**Our Ref: C21/99**

**West Culburra Mixed Use Subdivision (SSD-3846)**

Thank you for your referral of 14 January 2021 seeking advice on the above proposal from NSW Department of Primary Industries (DPI). The following advice includes input from the Aquaculture Management Unit and Coastal Systems Unit of DPI Fisheries and the NSW Food Authority, and considers the amended project design, revised EIS and supporting documents for the referral.

Diagram 11: Stormwater management scheme for the Concept Plan.

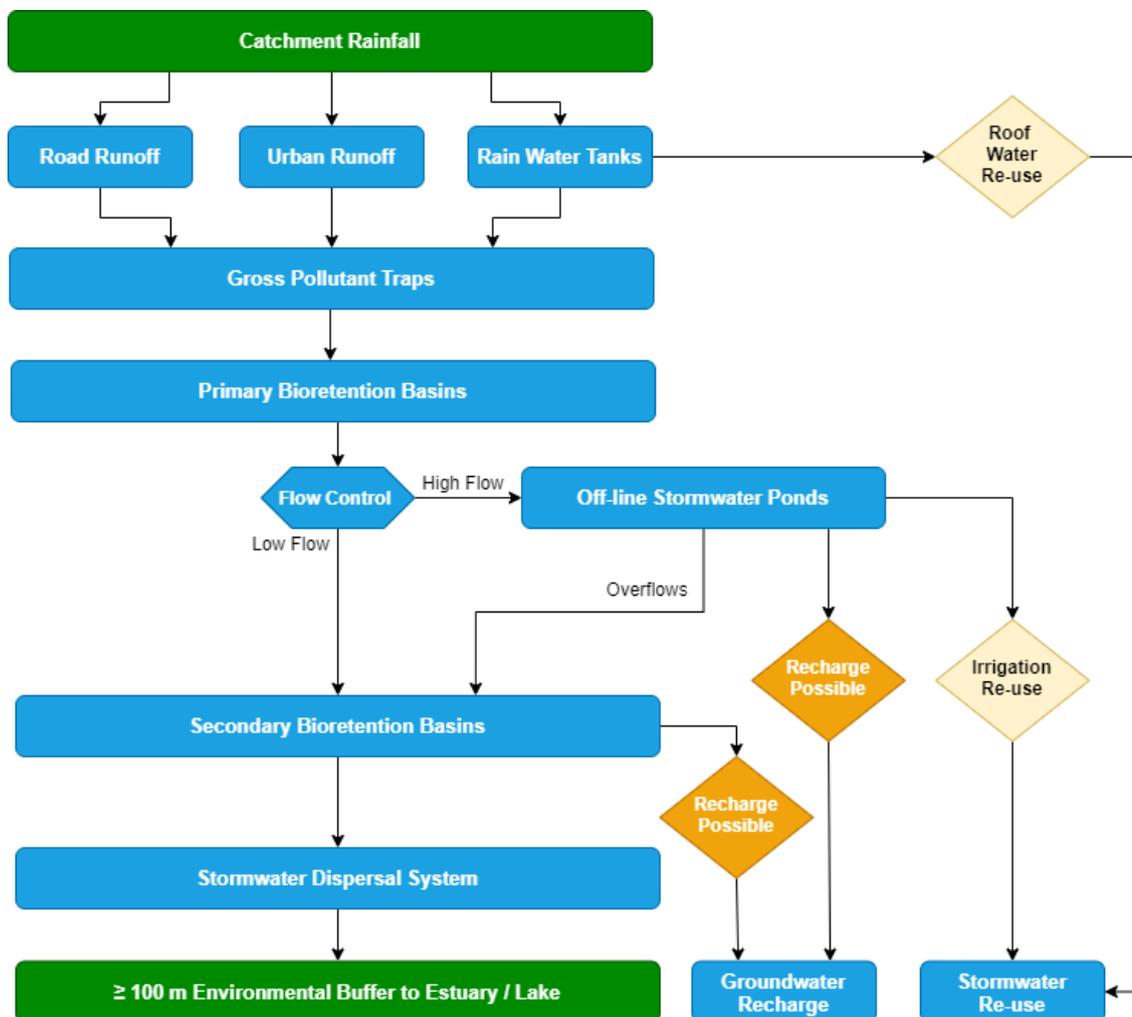
DPI Fisheries would like to confirm that installation of the proposed water sensitive urban design infrastructure to manage rainwater runoff will meet the NorBE objective, to achieve no increased nutrient and sediment load to the estuary. Consequently, we would like to confirm if the proposed rainwater infrastructure is designed to capture 1 in 20, or 1 in 100 year rainfall events. Further, DPI Fisheries recommends that an independent review of the inputs into the MUSIC modelling be conducted to provide assurance that the stated NorBE objective will be achieved.

DPI Fisheries notes reference to no new stormwater outlet pipes being installed from the development. We would like to confirm that excess rainwater leaving the development site through existing stormwater pipes will not result in additional scouring and increased sediment load, or cause re-suspension of sediment in the estuary.
